From: Clare Dales
Sent: 14 November 2017 09:34
To: Simon Davis
Subject: RE: The Whyke House, 47 Felpham Way - FP/175/17/L

Subject: The Whyke House, 47 Felpham Way - FP/175/17/L

EXISTING & PROPOSED ELEVATIONS

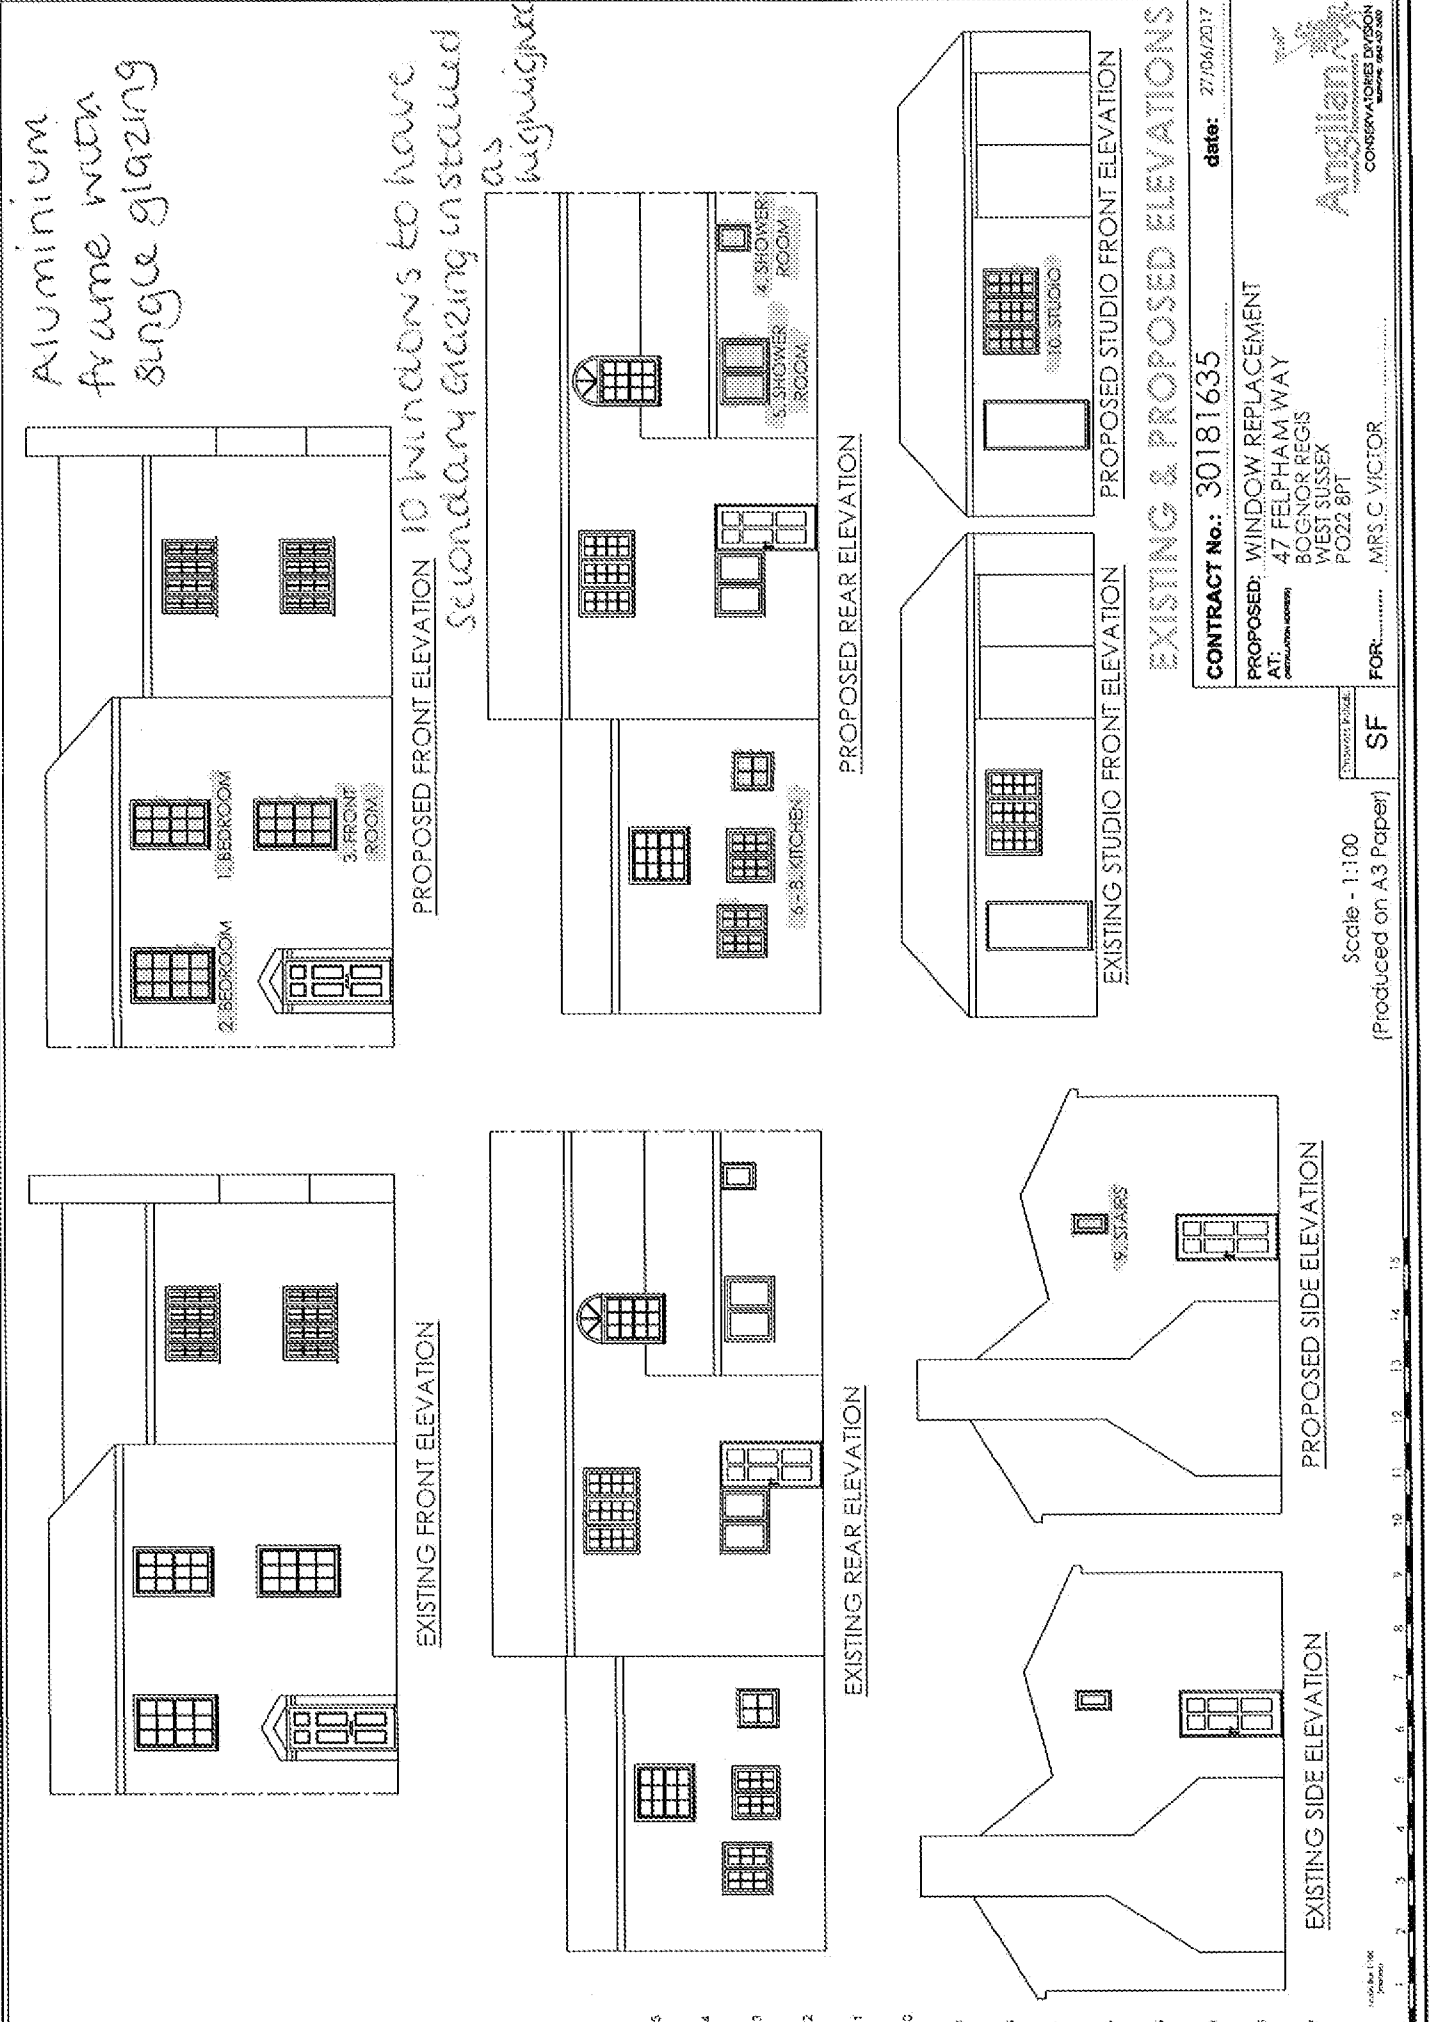
Yes, my comments still stand. They have indeed read the Historic England advice on glazing in historic buildings, but it does say, that all historic buildings are unique and their advice is general and should be considered on a case by case basis. It would not be advisable/possible to install at the property due to the shutters.

"Generally, I'd say no to this, as secondary double glazing is as intrusive visually as double-glazing. That is to say there are two layers of reflectivity which inevitably has an adverse effect on the appearance of the property as a whole. In this case, secondary glazing would also encroach on the historic timber window reveals (and possibly shutters – although they have not photographed all windows). In addition to this, the submitted photographs (towards the end of the application), show secondary glazing already in situ. This appears to be unauthorised, and should be removed."

With regards to the point made about the two layers of reflectivity we would like to highlight that the windows to the rear of the property are not overlooked so would not be intrusive to the community. In addition, as the purpose of secondary glazing is to allow the home owner a level of control of heat, in the warmer months when the sun is most likely to reflect on the glass the secondary glazing would be open and only in the colder months, when they would be closed there sun reflection would not be an issue.

Secondary glazing is not a permanent structure and is fully removable and therefore the original windows remain untouched and can be maintained in the future to ensure their further longevity.
